Subject: ACU-25-00002 Boys & Girls Club - Notice of Application

RE: ACU-25-000002, Boys and Girls Club
SR 903 milepost 3.45 Rt.

TO: All Staff
FROM: Public Works Plan Review Team
DATE: September 11, 2025
SUBJECT: ACU-25-00002 Boys & Girls Club

SEPTIC SITE PLAN

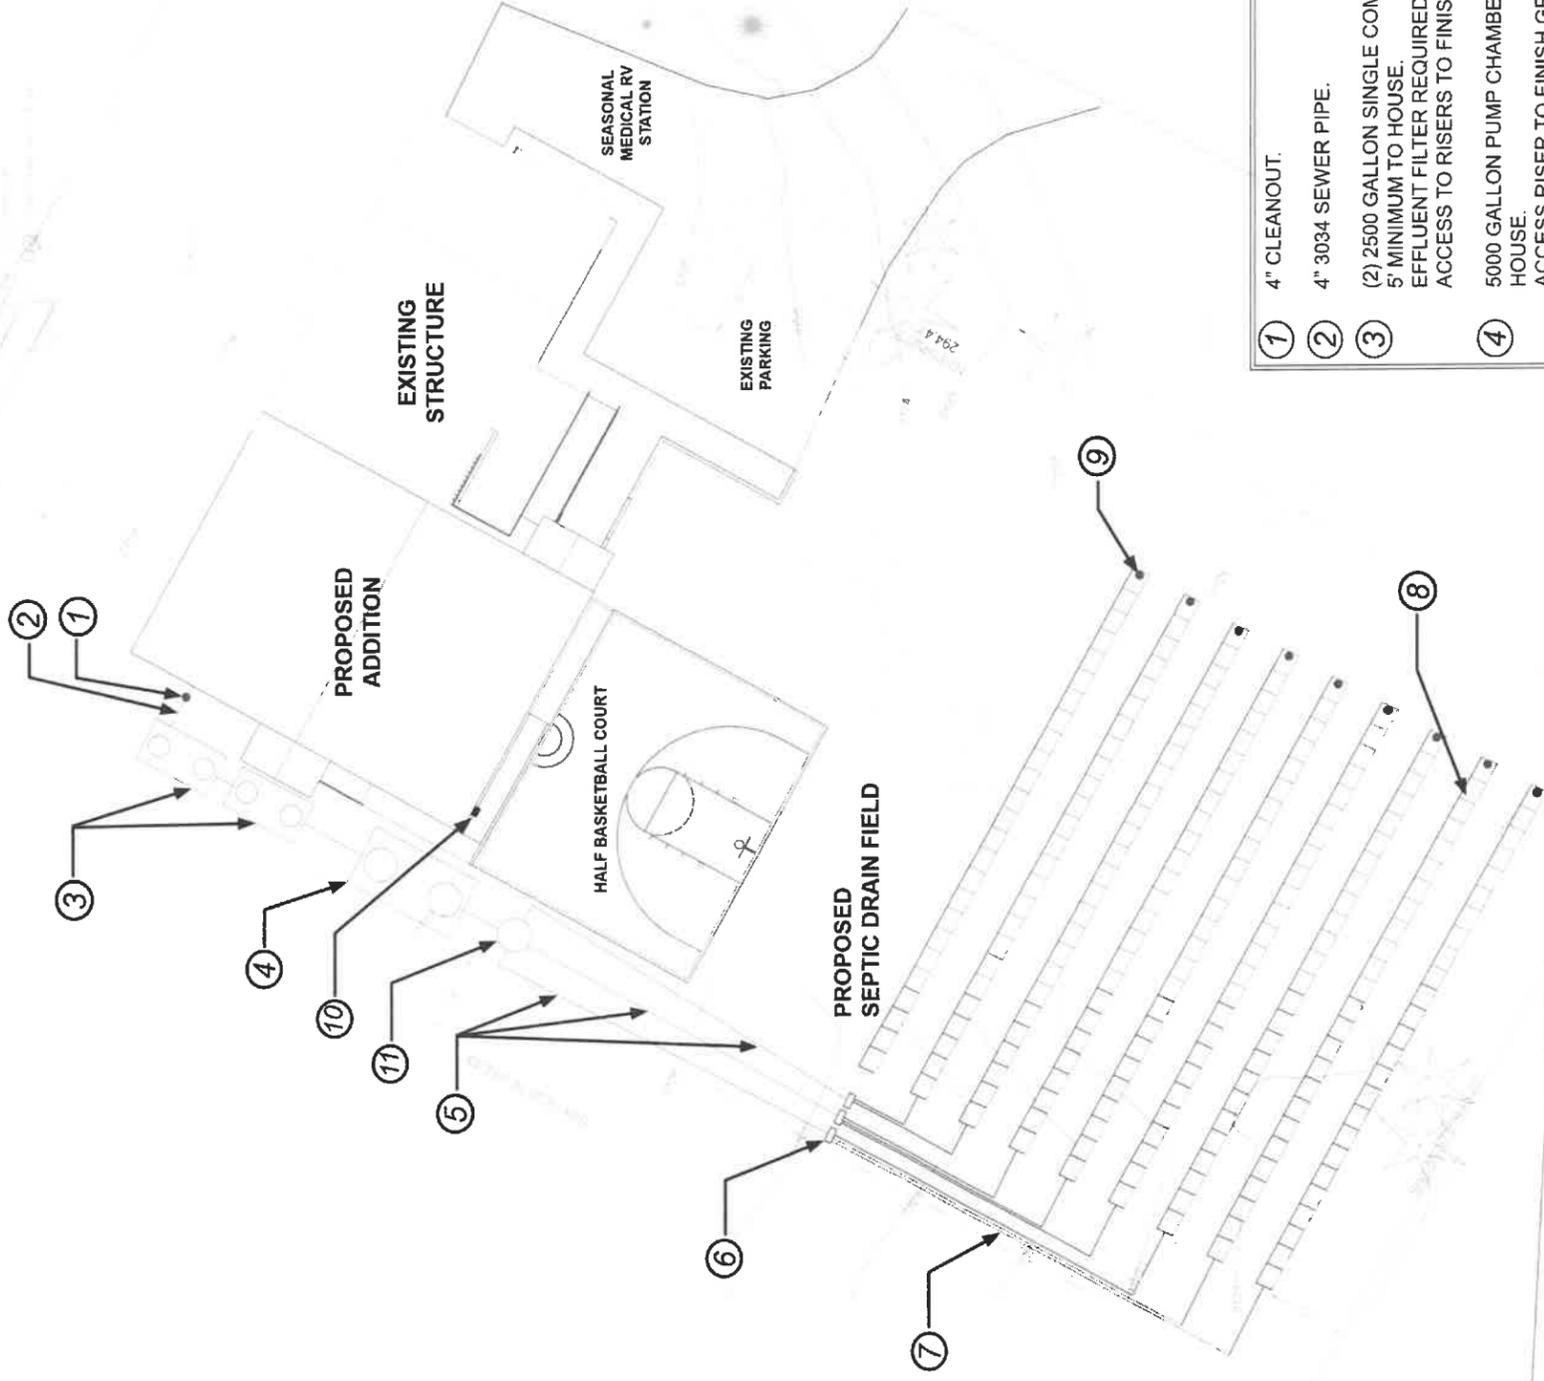
SURVEY	As the proposed site plan does not show property boundary lines, and the development proposal appears to be quite tight to fit on the existing property, applicants are reminded that they must adhere to setback requirements. It is strongly recommended a land surveyor be utilized to ensure that the proposal does not encroach or trespass onto adjacent parcels. (JT)
TRANSPORTATION CONCURRENCY	Provide estimated traffic counts for courtesy screening. Coordinate with WSDOT to identify additional concurrency requirements
FLOOD	No comments. (SC)
WATER MITIGATION/ METERING	No comments. (SC)
AIRPORT	No Comment. (RC)
